Heckington Fen Solar Park

EN010123

Statement of Common Ground with Natural England

Document Reference: 7.6i

The Biodiversity Metric 3.1 - Calculation Tool Start page

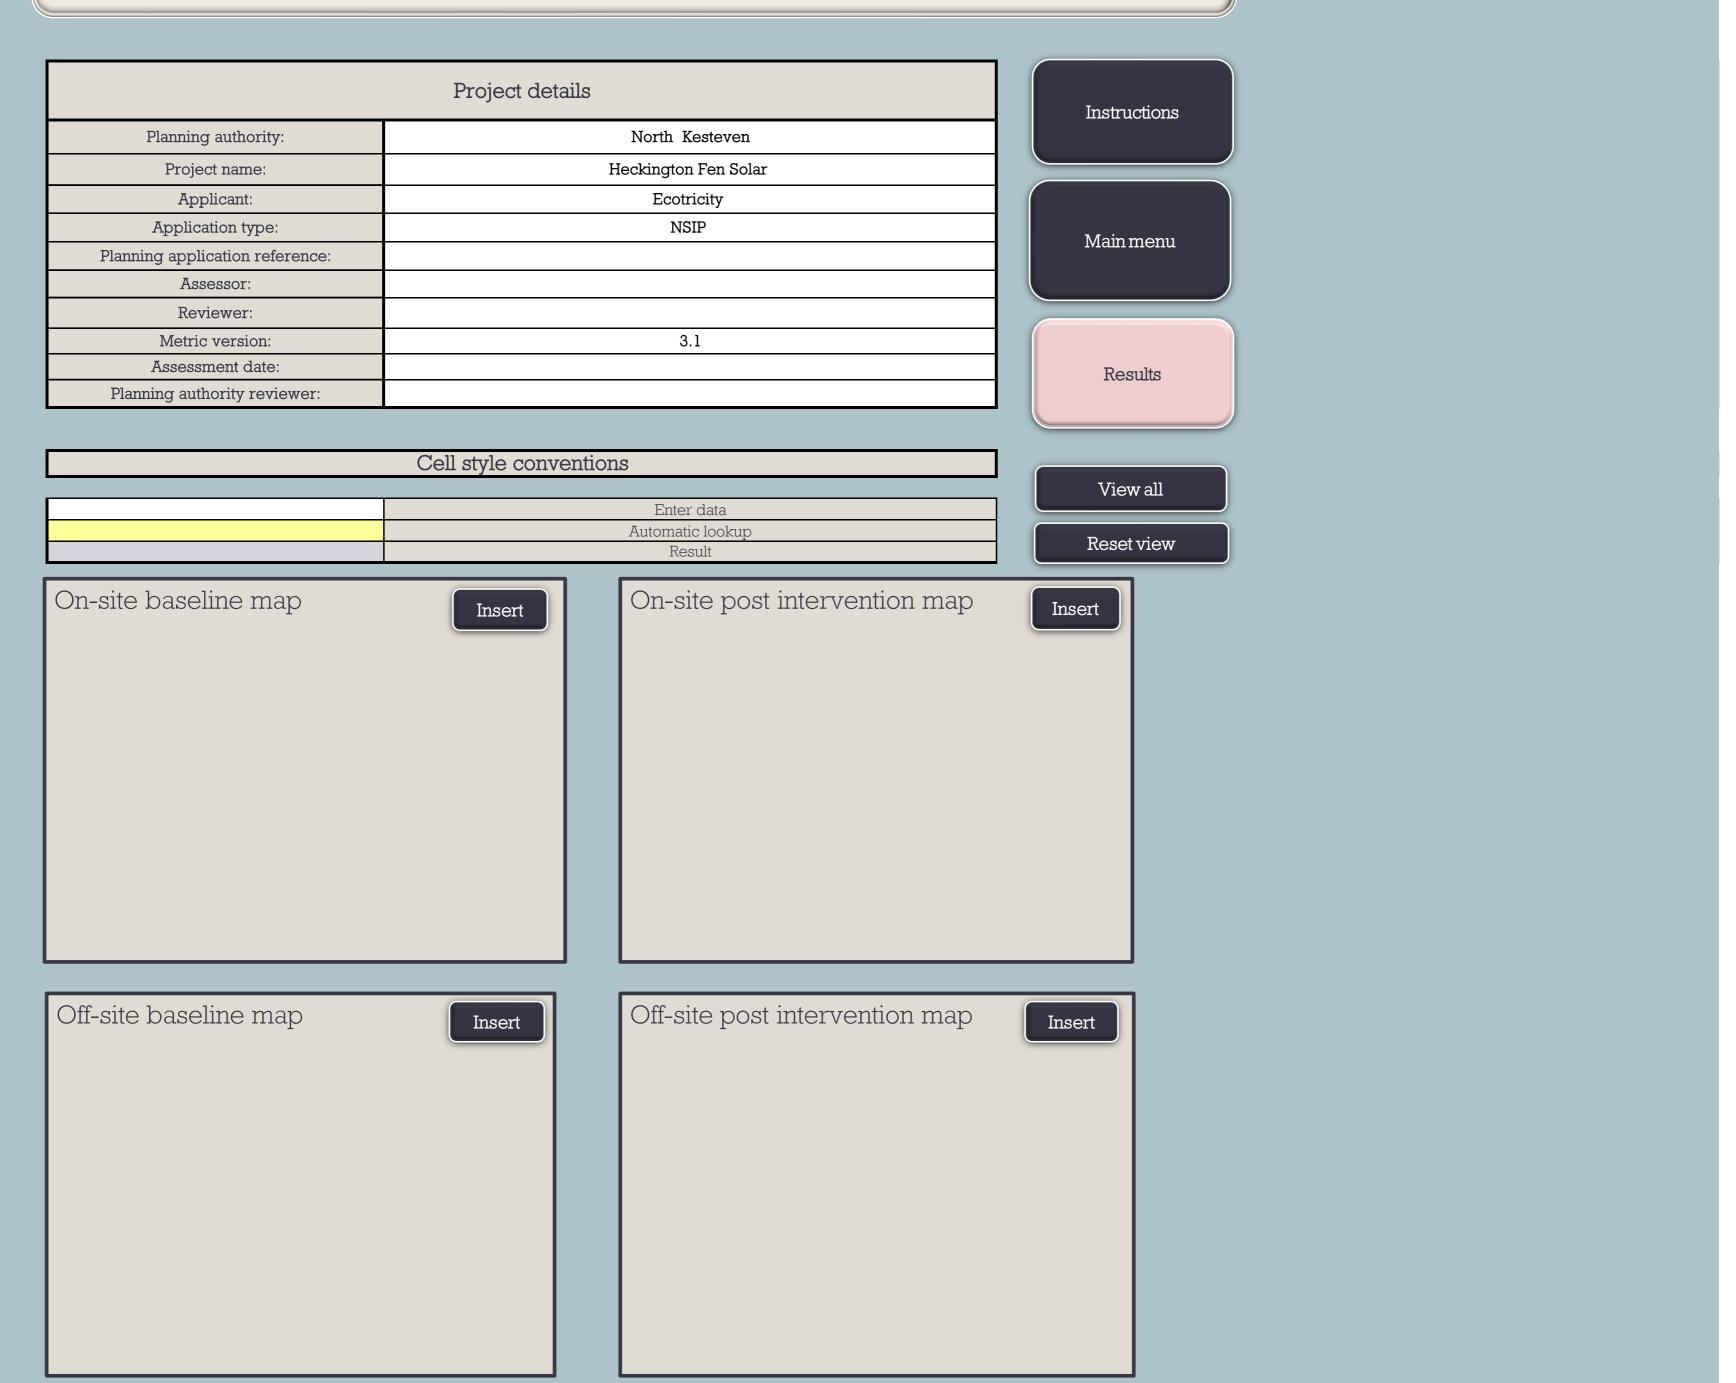
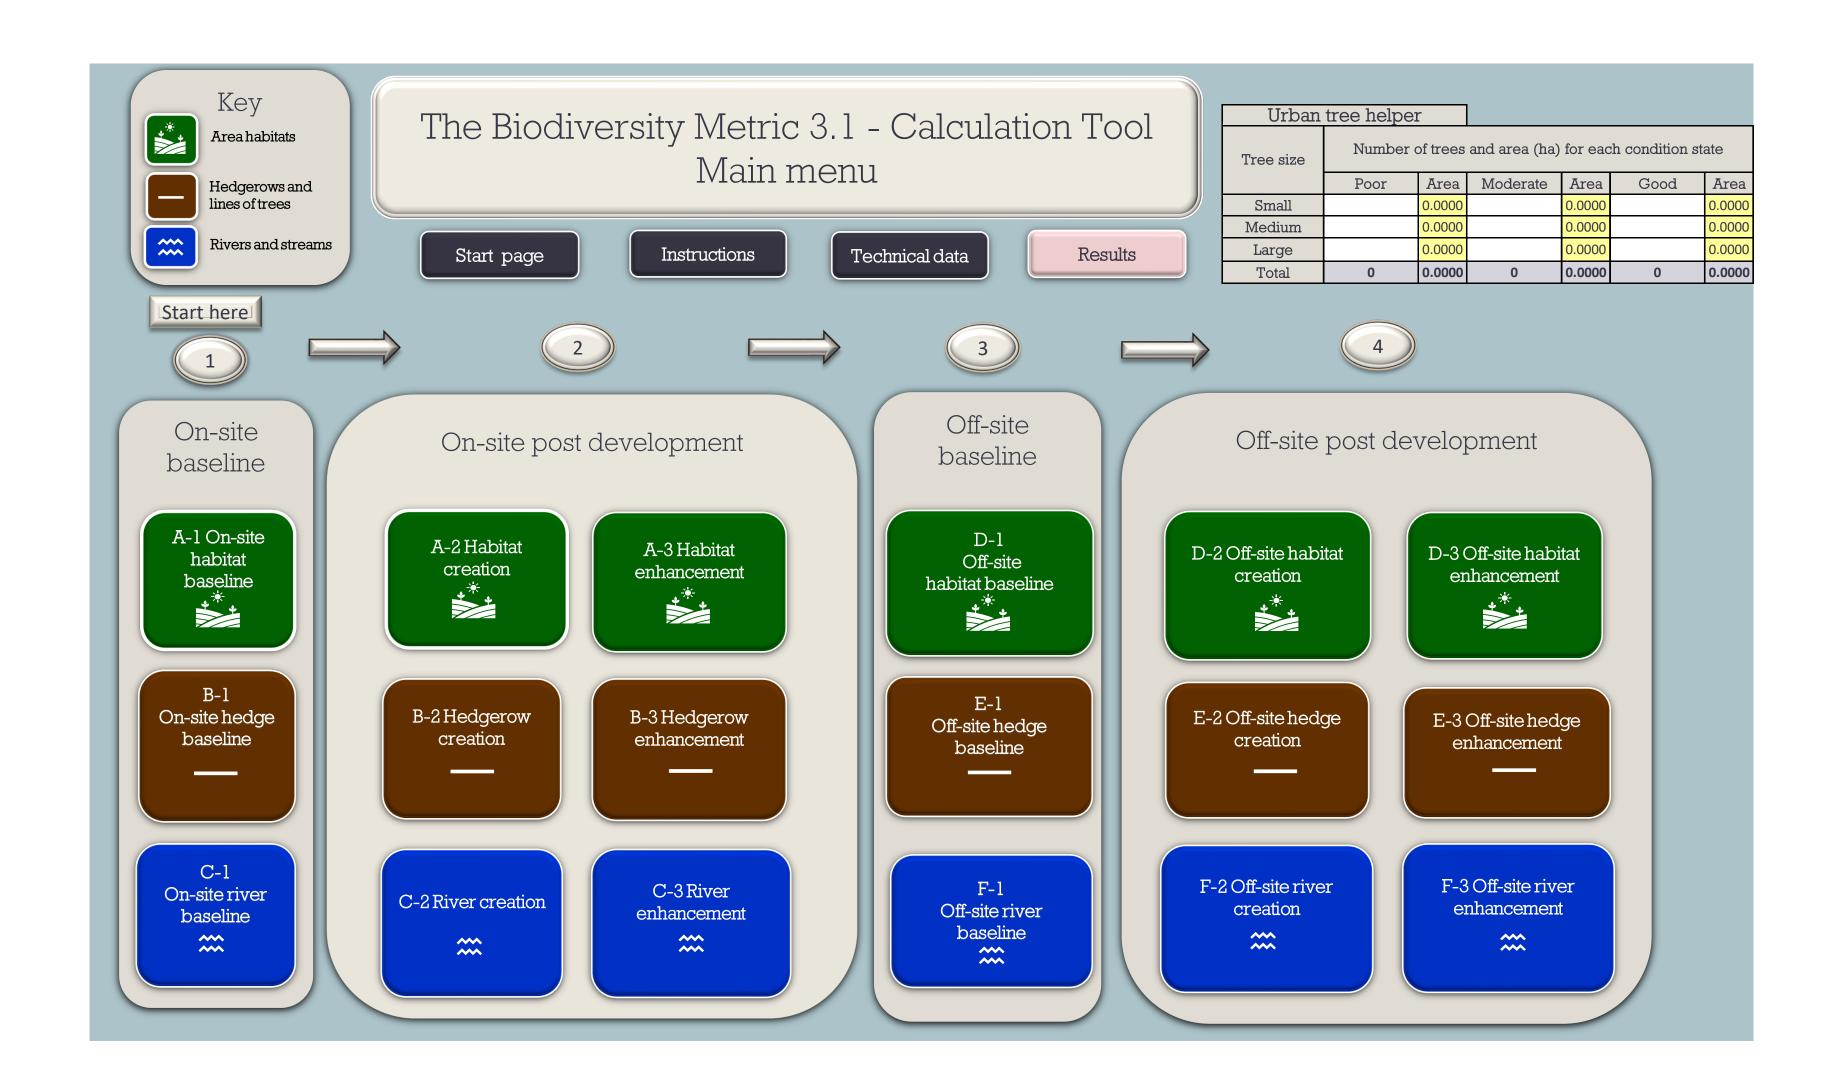
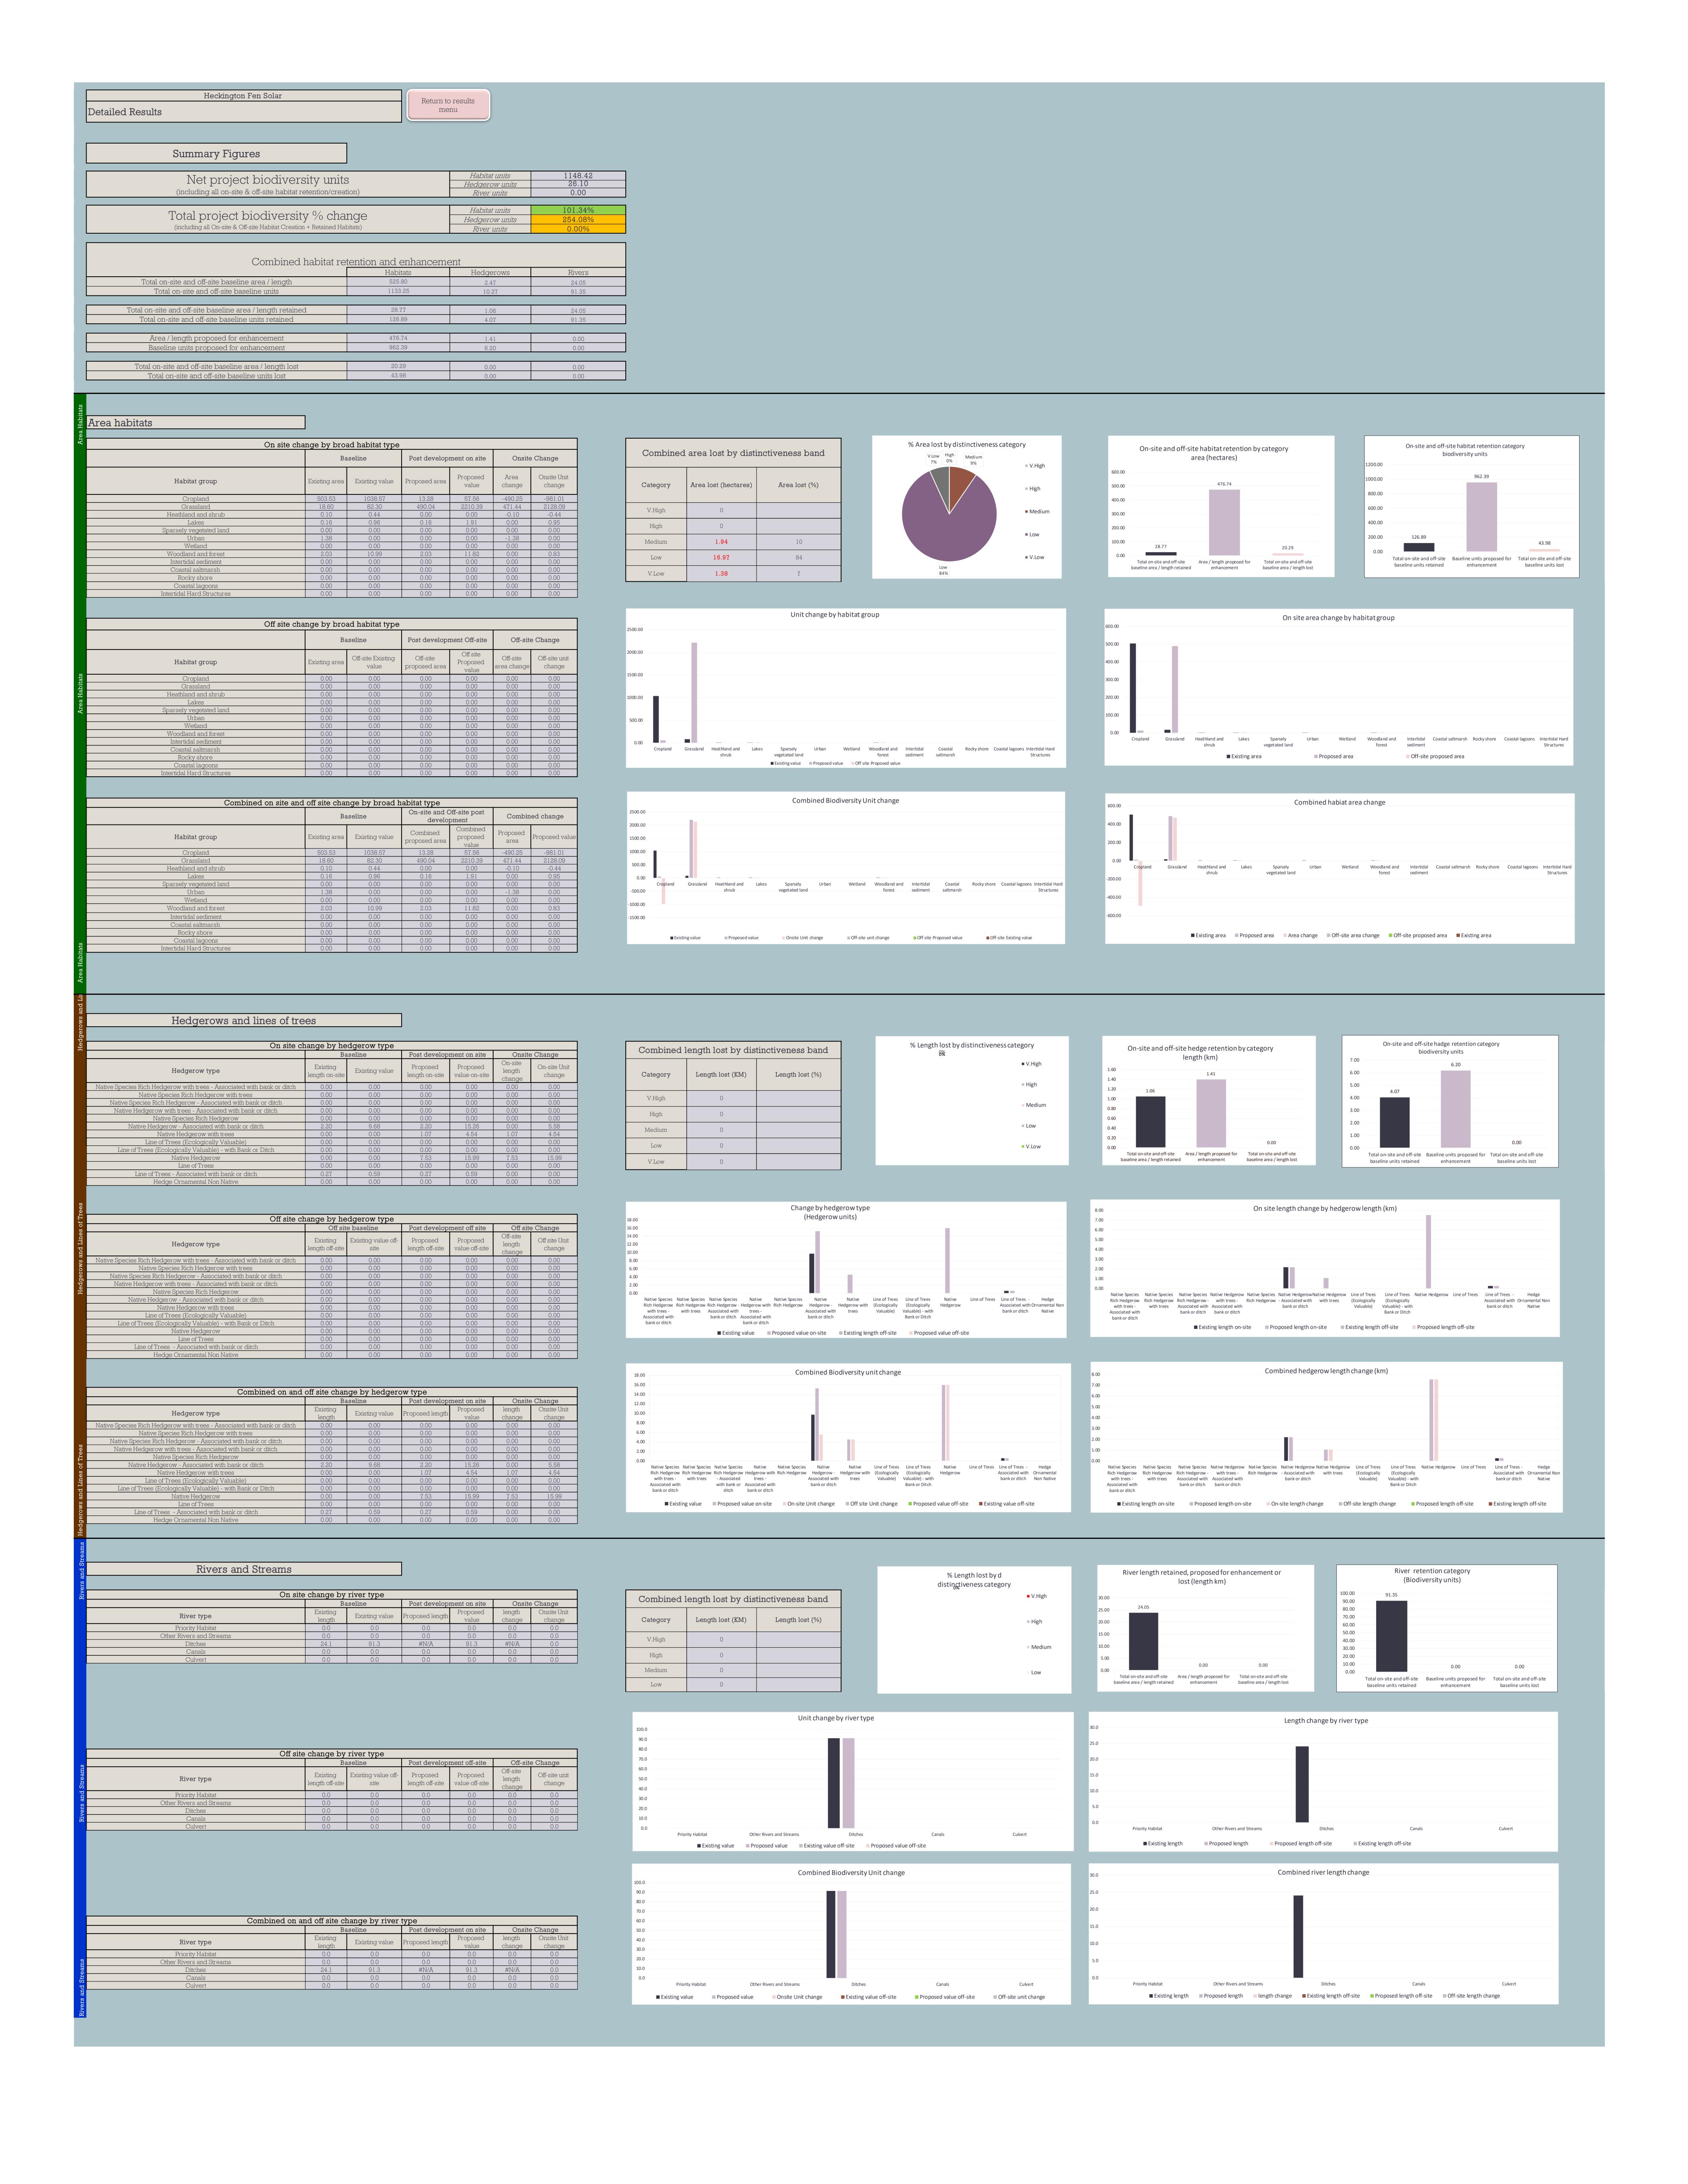
6. Biodiversity Net Gain			
6.1 Agreed	Biodiversity Net Gain Metric 3.1 used (Appendix 8.12) provided to NE on 20 th June 2023.	NE welcomes the commitment to deliver BNG and is generally supportive of the enhancements proposed through the development. The enhancements detailed within the oLEMP, are welcomed and are likely to indirectly have a positive effect.	The Applicant notes NE's comments made in relation to BNG during consultation which are generally supportive of the enhancements proposed, and detailed in the oLEMP.
